From: [REDACTED]
To: [Cleve Hill Solar Park](#)
Cc: [REDACTED]
Subject: Deadline 3 Submission - Impact on Local Businesses
Date: 31 July 2019 14:36:34
Attachments: [REDACTED]

Open Floor Hearing 1 – 16 July 2019

Impact on businesses, including tourism

GREAT representing the villagers

Construction Traffic Routing
Figure 14.1

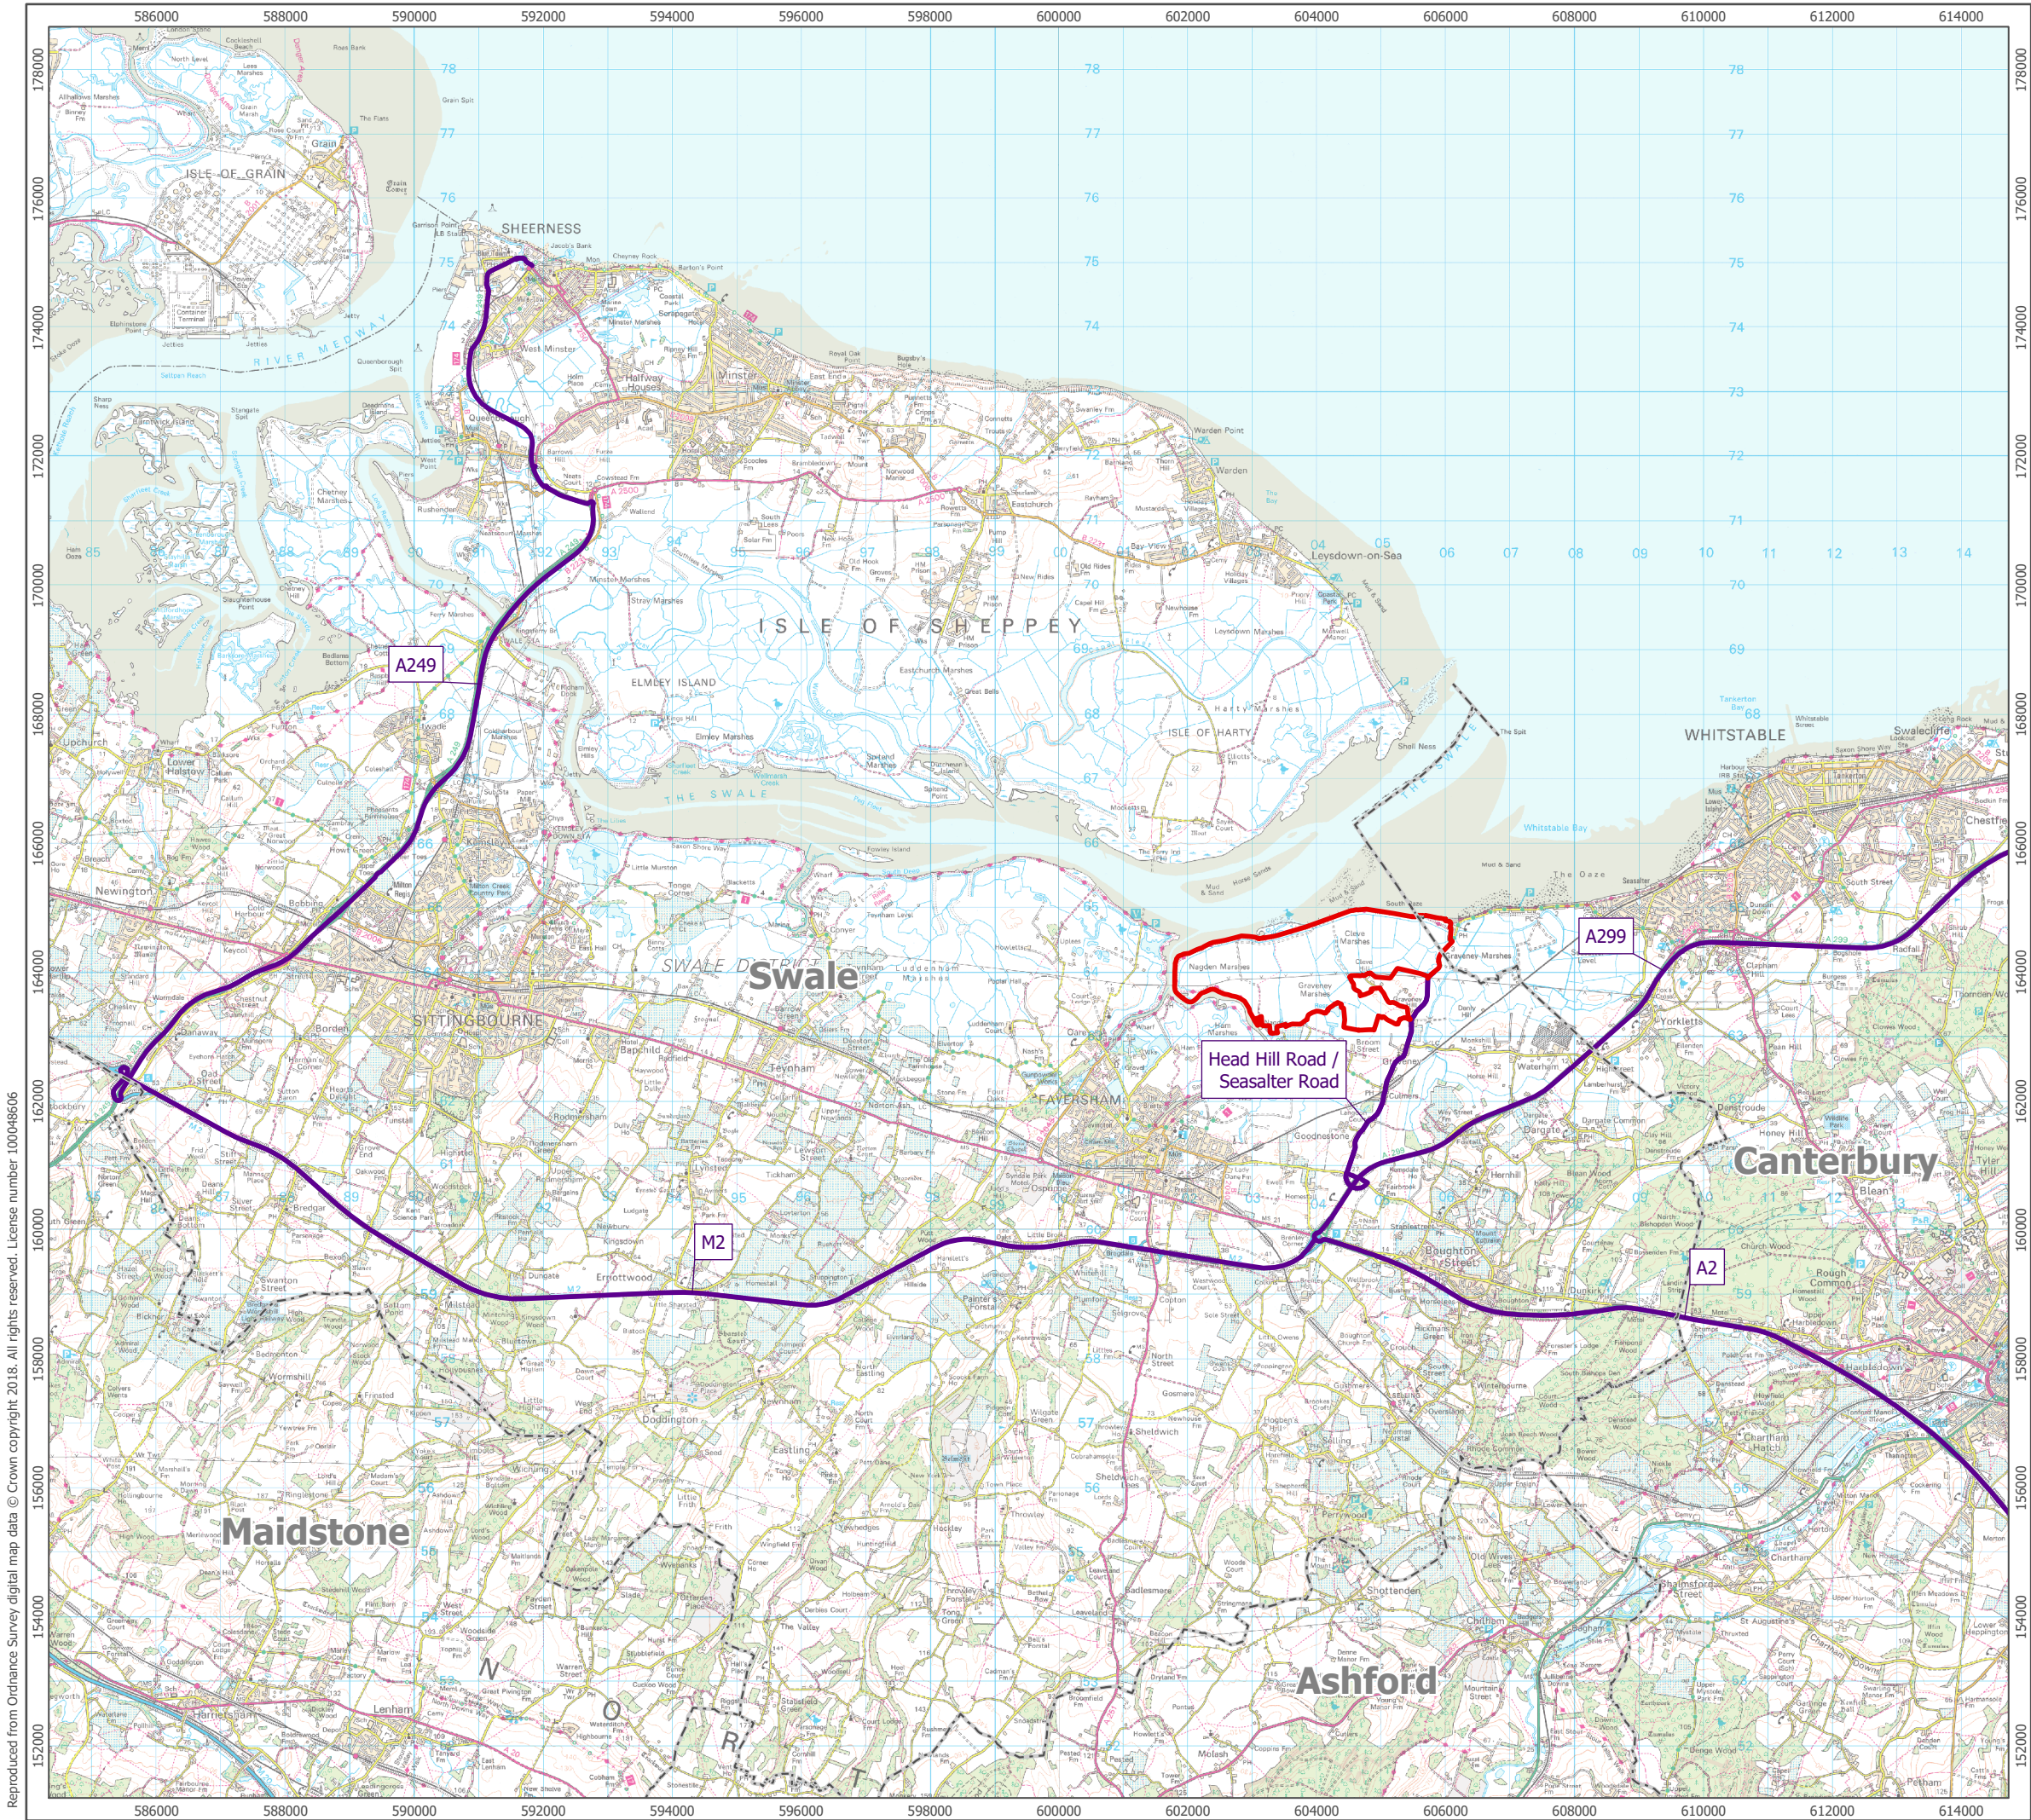
The primary route for traffic is from the top of Head Hill Road to the London Array substation access road - a distance of some 2 miles. The ‘Sensitive Receptor’ map produced by the applicants (Environment Statement Volume 2, Figures – Access and Traffic) identified just 6 receptors impacted by the development (see Figure 1 below). Along this short distance there are actually 23 quite diverse local businesses that use this route (see Figure 2 below). They include a number of farms, a removal firm, a transport services company, the village school, two further educational care facilities, an equine centre, a holiday park, the Church, the village hall, London Array, National Grid and a skip company. All of these rely on good and unhindered access.

Hilderbrands removals are very concerned as the company operates HGVs and says it is already impossible to freely pass with one HGV and one car in the stretch of road from their depot to the top of Head Hill Road. They said this is particularly difficult on the 2 areas of road that narrow where there are double bends. They also pointed out that they only work 9 to 5 so as not to disturb the villagers - there is no such consideration from the developers who will be operating from 6 am to 8 pm. They expressed concerns that the road does not have capacity to take further traffic, particularly as it is further exacerbated when a traffic incident occurs on the A299 Thanet Way, resulting in complete chaos when diverted traffic funnels through the village.

**Public Rights of Way
and NMU Survey Locations**
Figure 14.3

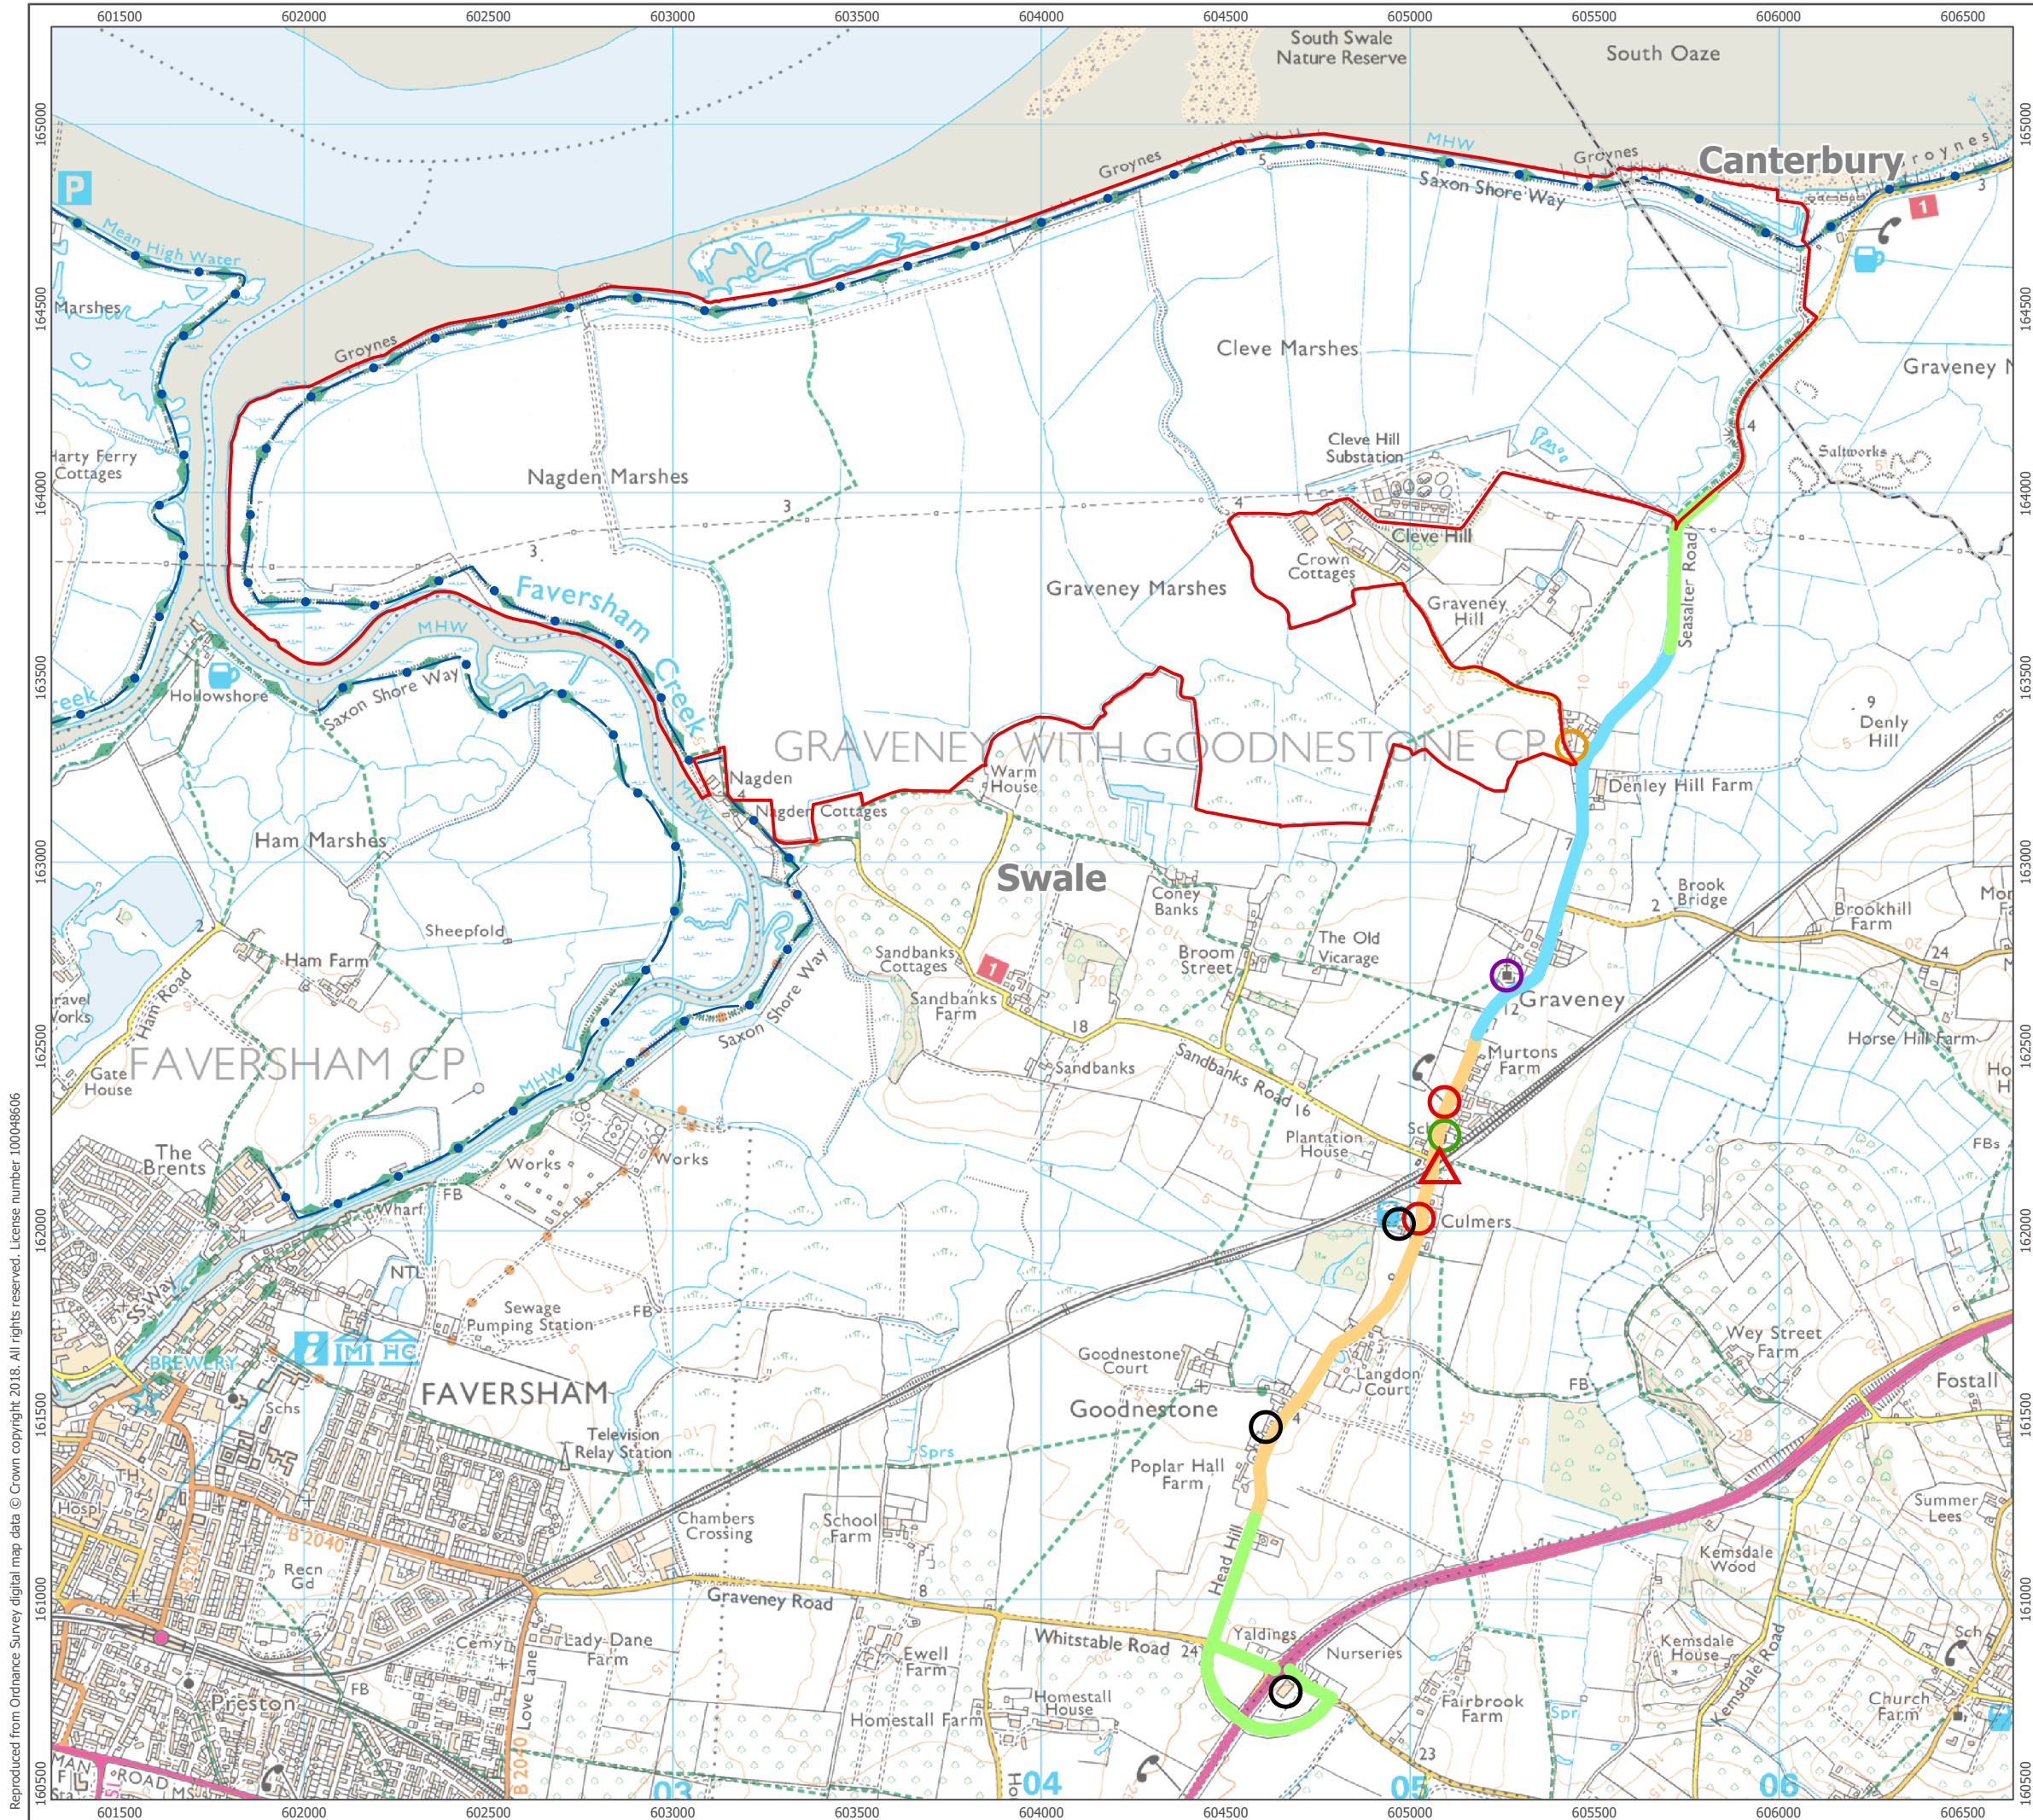
What has not been included on the applicants Sensitive Receptors map are the businesses beyond the London Array entrance which also use Headhill Road and Seasalter Road. This includes the Michelin star Sportsman restaurant, the Seasalter Chalet owners, Seasalter sailing club, Waldens shop, Forget Me Not café, Waldens caravan park, Alberta holiday park and the Oyster Pearl pub. Due to the low bridge in Seasalter all large vehicles bound for these businesses have to come through Graveney, including caravans being transported to and from the caravan parks.

The inaccuracy of the Sensitive Receptors map also includes a public telephone in the village that no longer exists. It is evident that the applicant's overview evidences the lack of real engagement with the community as the information presented bears little resemblance to reality.

We are very concerned that this information has been used to inform other organisations or documents. For example, if the traffic management plan is based on the applicant's incomplete and inaccurate information then the villagers should be given an explanation on who submitted this information, how it was obtained, and why it is so incomplete.
